Summary statement regarding matters that have previously been raised during the examination and have not been resolved.

Drawing file: EN010133 / EN010133-000396-C6.4.8.16.1 Figure 8.16.1 Landscape and Ecology Mitigation and Enhancment Plan - Cottam 1_North_Sheet 1.pdf

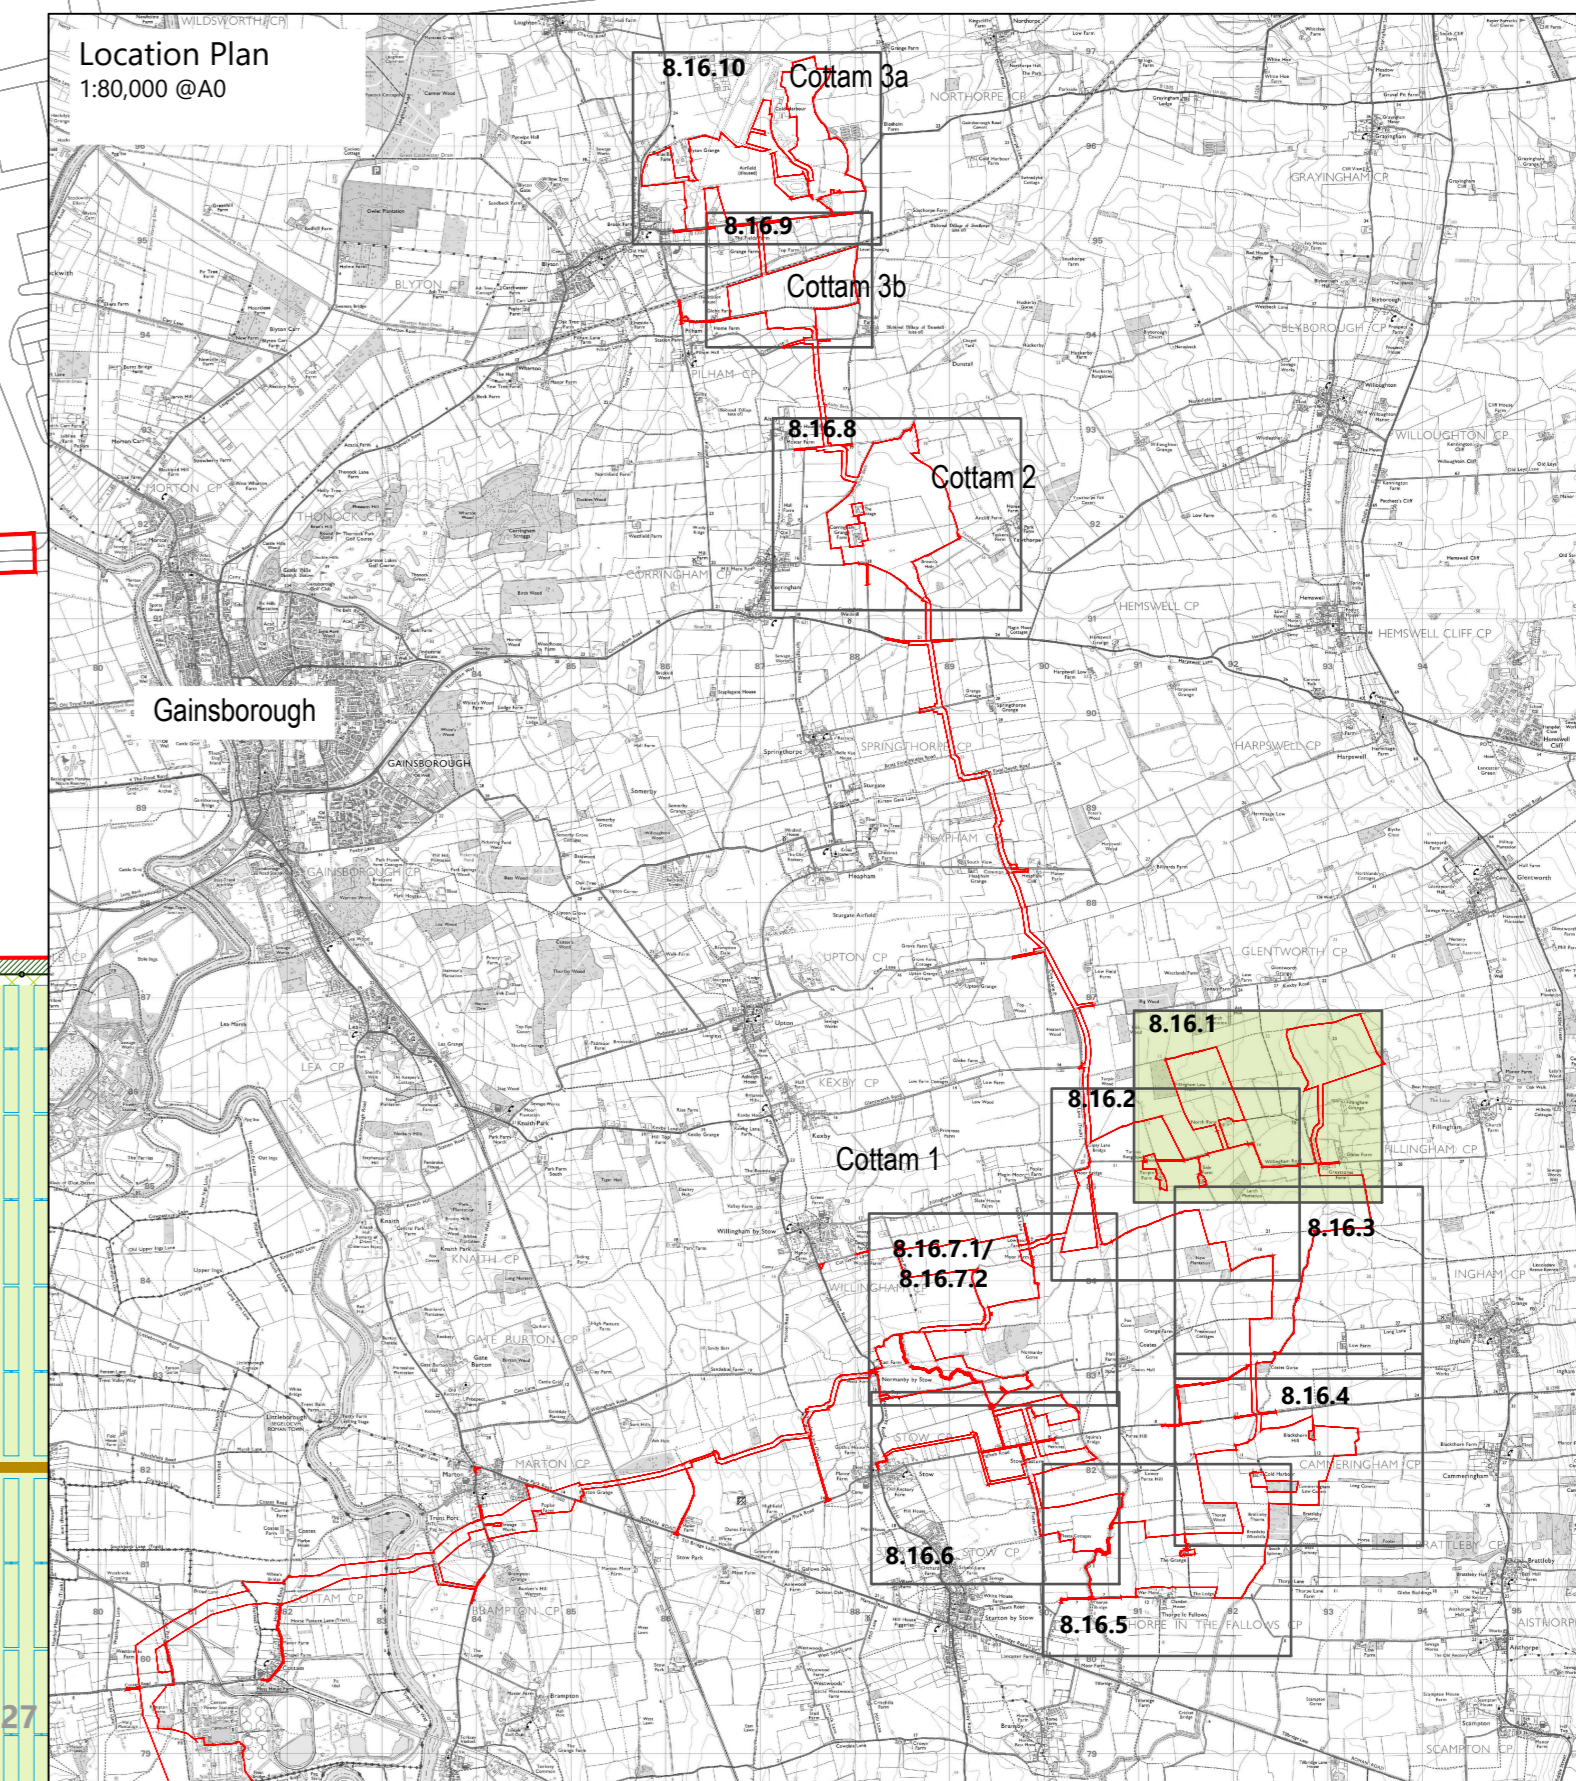
Applicant's response to DL 4. SKS.01 My suggestions to relocate the proposed mitigation/wildlife fields to around our home, increasing the buffer zone, have been dismissed yet again, with the Developer thinking they can hide hundreds of acres of 4.5m structures behind new hedge planting. This would take a lifetime. Why will they not listen to us? A larger break between us and the solar arrays will obviously reduce harm, it is as simple as that. Our property value and future B&B income stream would be very much compromised by the scheme's unnecessary proximity and its clearly devastating industrial impact on the landscape. "Planting up" as soon as possible should be standard practice. The arrays located further away would resolve a major issue. Not even a small compromise has been secured during this process.

I also asked that Important Hedgerows H154 and H 155 to be removed from the DCO as there is no need for these to be included. These hedges provide screening, south and west. H154 belongs to us and not the landowner.
